**Harnett County**  
420 McKinney Pkwy  
LILLINGTON, NC 27546  
Phone:  
Fax:

10/15/2024

**SUBJECT: BRES2405-0069**  
**BUILDING RESIDENTIAL**

Here are the results of all Inspections located at **524 LONGLEAF DR:**

FOOTING PLAN	
FOOTING DETAILS	
524 LONGLEAF DRIVE—LILLINGTON, NC	Scale: NTS
Date: 9/9/2024	Revisions:
Donald D. Paschall, Jr., P.E. (PE License # 22543) 318 S. Spruce Street — PO Box 291 Proctorville, NC 28375 (910) 734-2005 donaldpaschall@gmail.com	
2 OF 2

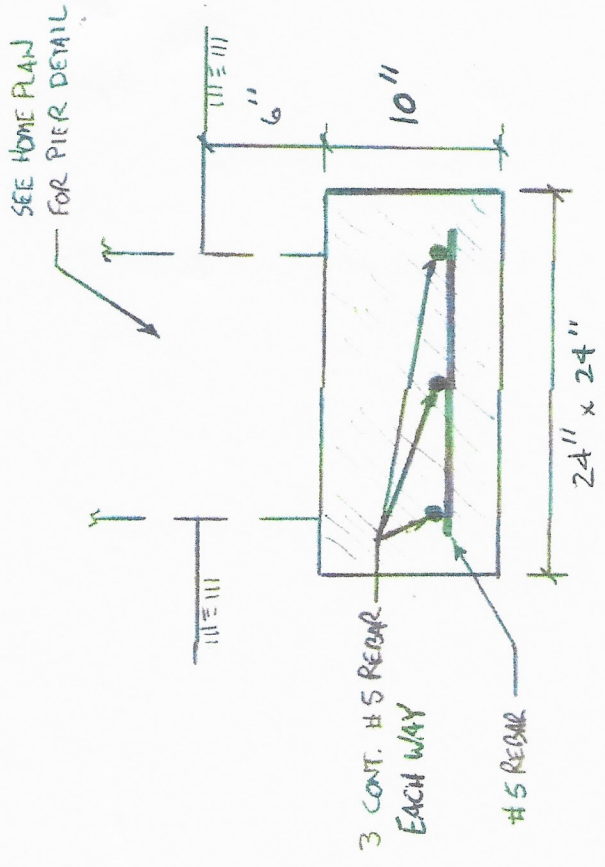
No plans in permit box  
Need to clean loose dirt from bottom of footings  
Need to mark depth of footings  
Missing step downs in footings

Need plans Full of water

Footing has water in them. Need to clean out and has crush and run in the footing. Need engineer letter
